SUNSET VILLAGE FILING NO. 4

CONSTRUCTION PLANS

[Signature] 12-19-01
JOHN A. MCCARTY, P.E. DATE
COUNTY ENGINEER/DIRECTOR
CONDITIONS

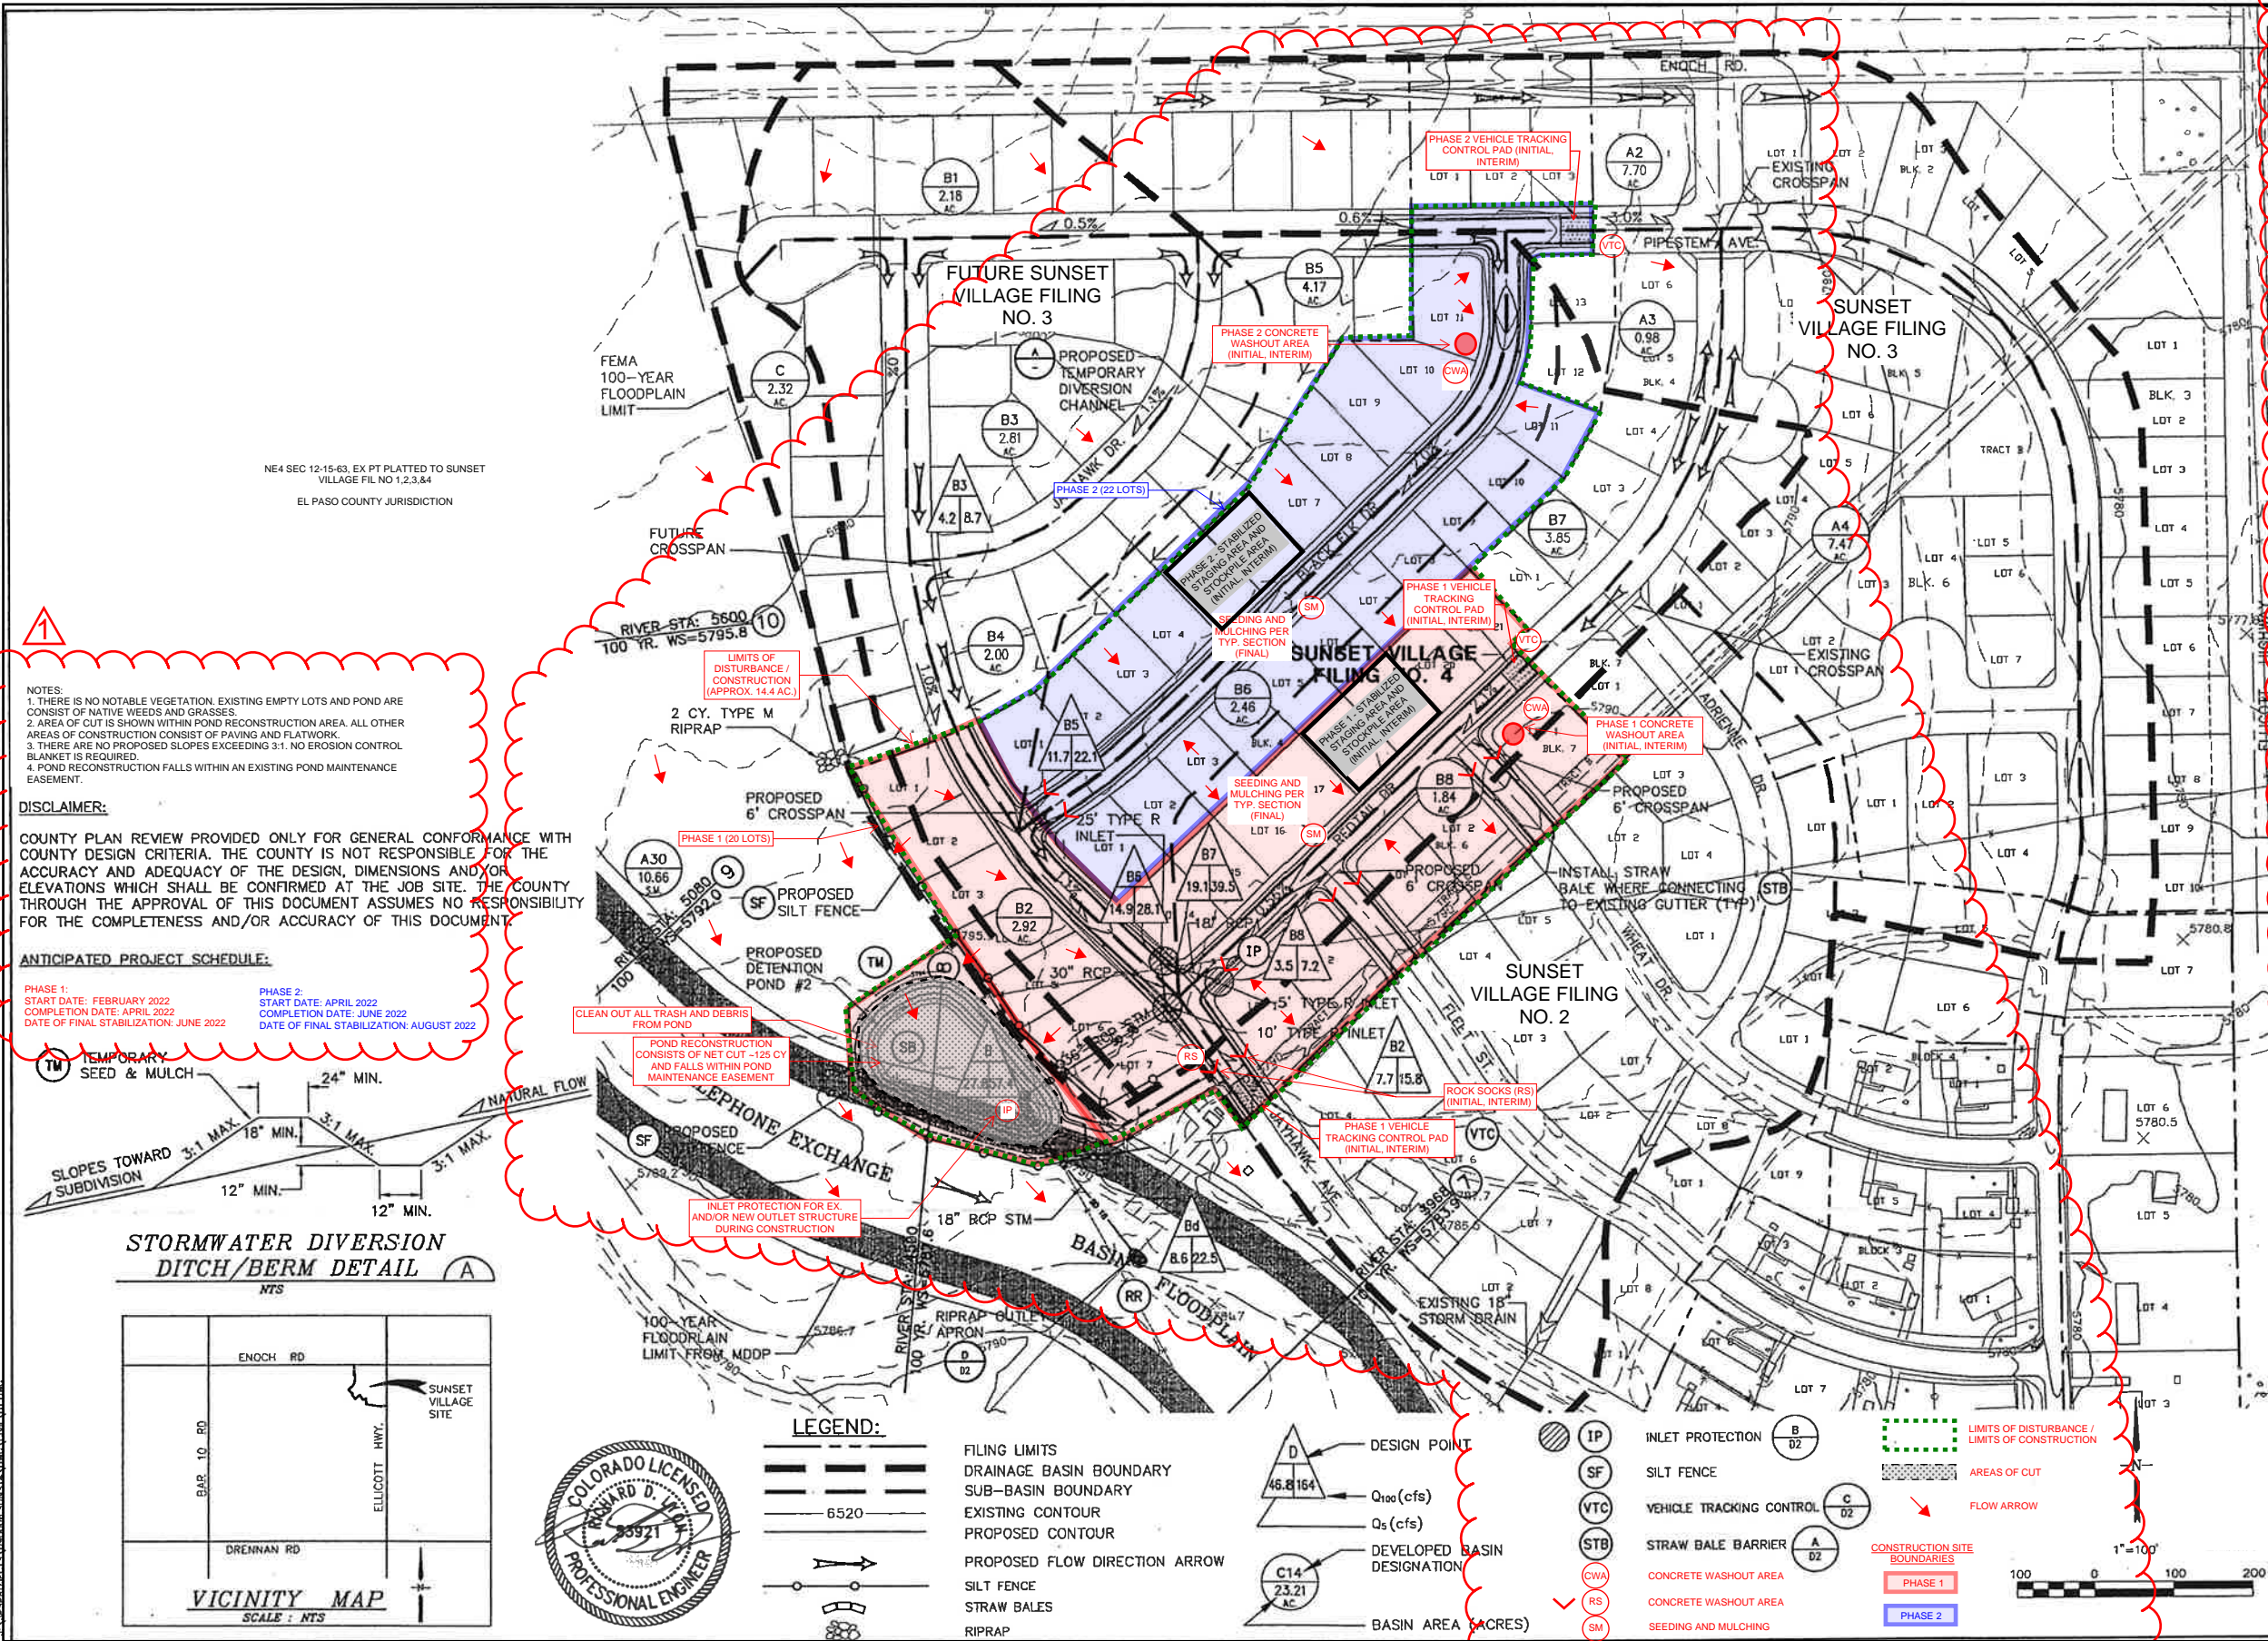
Markup the plans showing the limits/extents of improvements corresponding to the financial assurance estimate form (FAE).

Submit signage and striping plans and update the FAE accordingly.

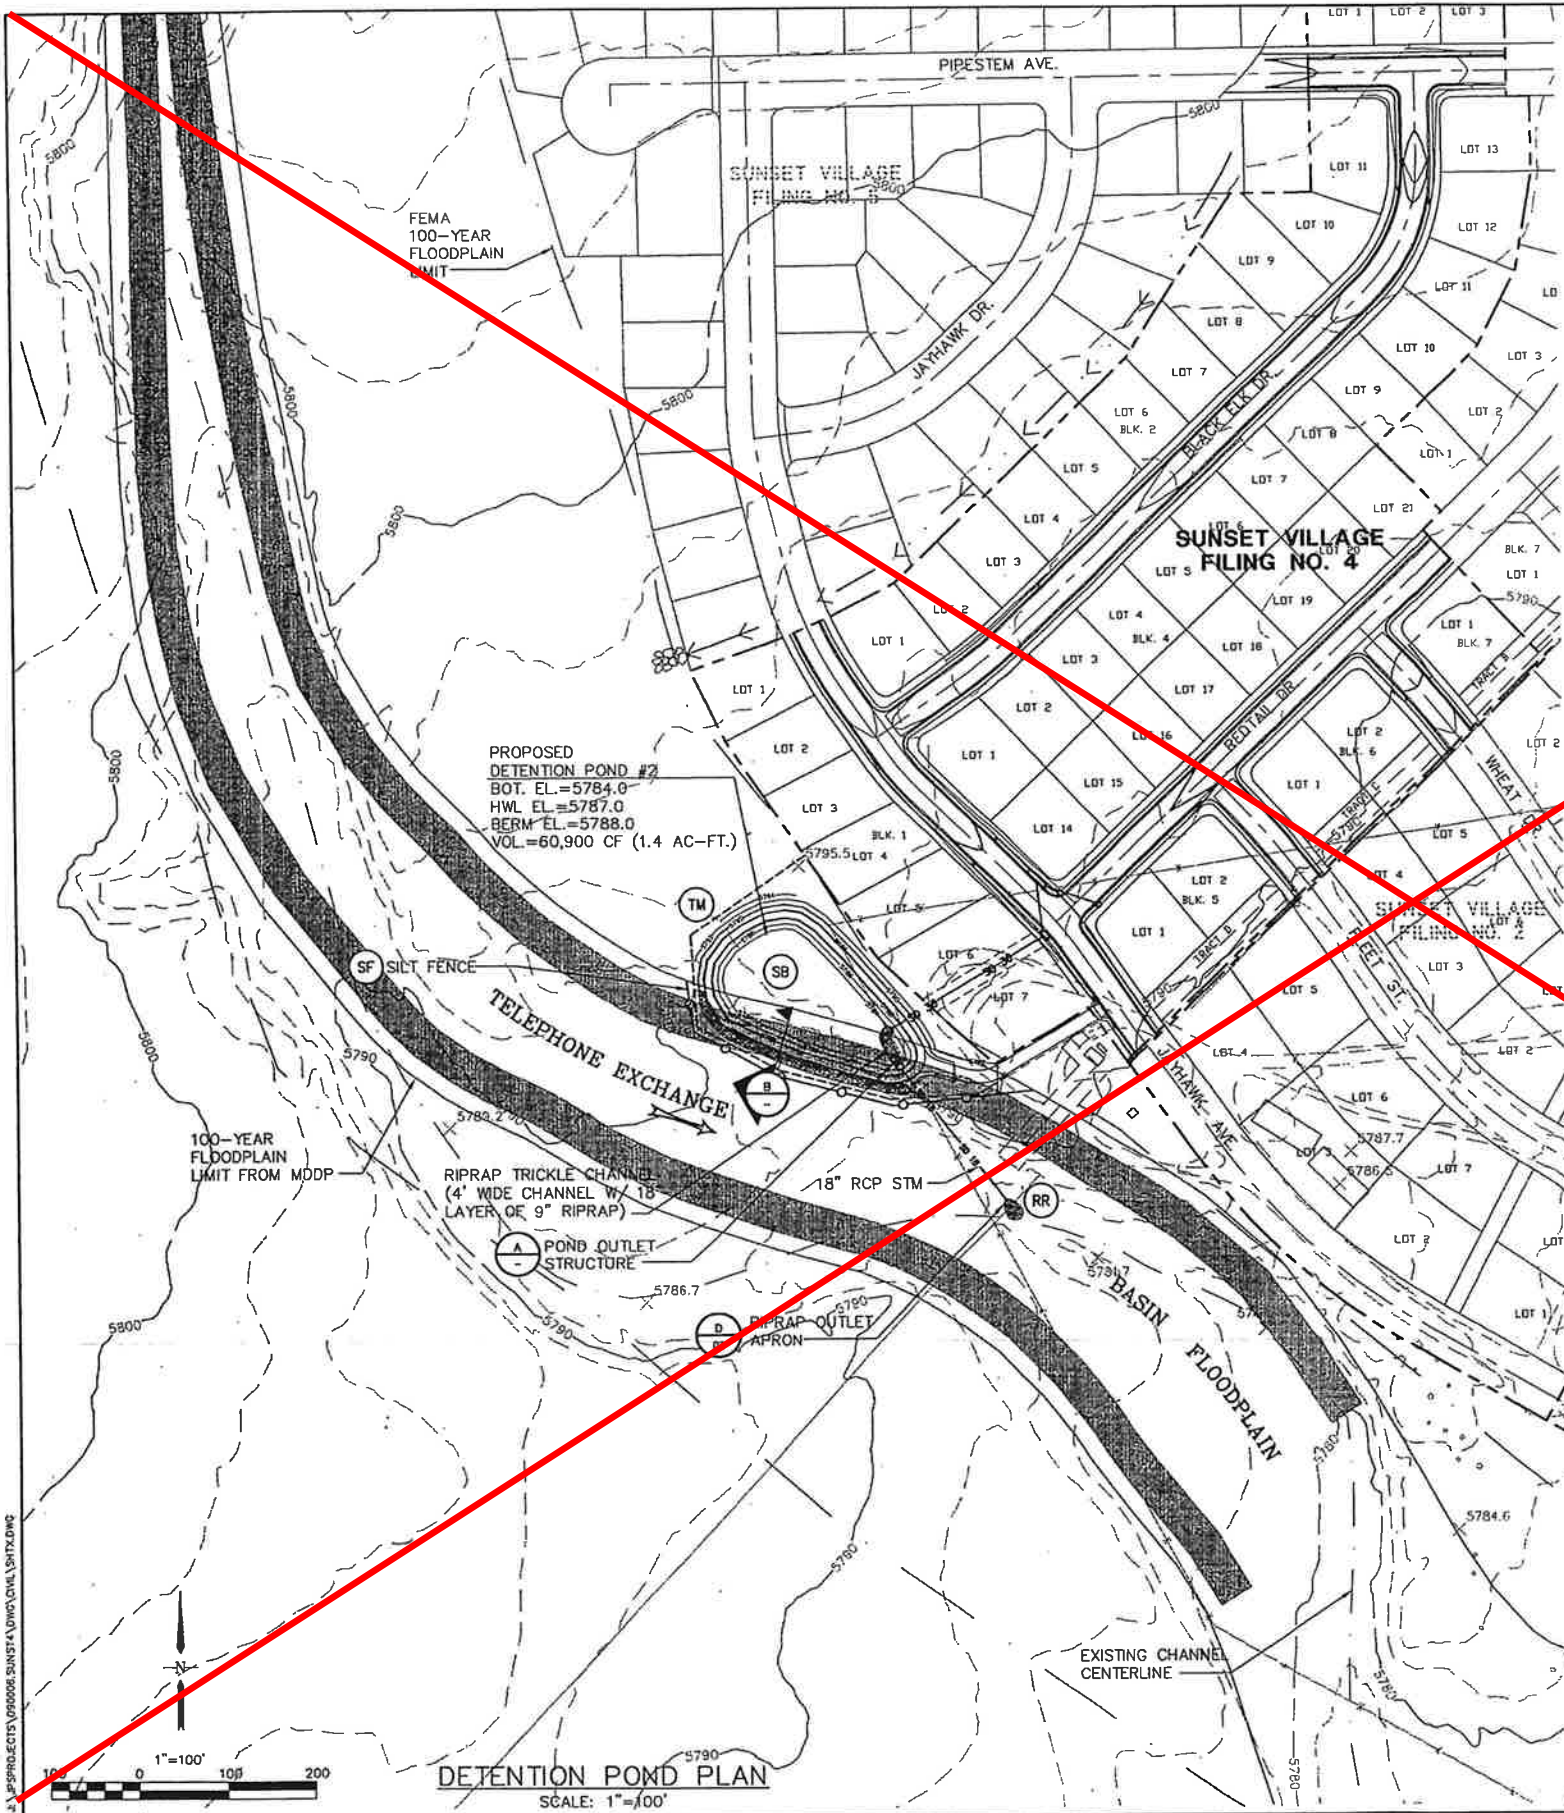
From aerial maps the area highlighted in blue is missing sidewalk that must be installed by the developer. Update the financial assurance estimate.
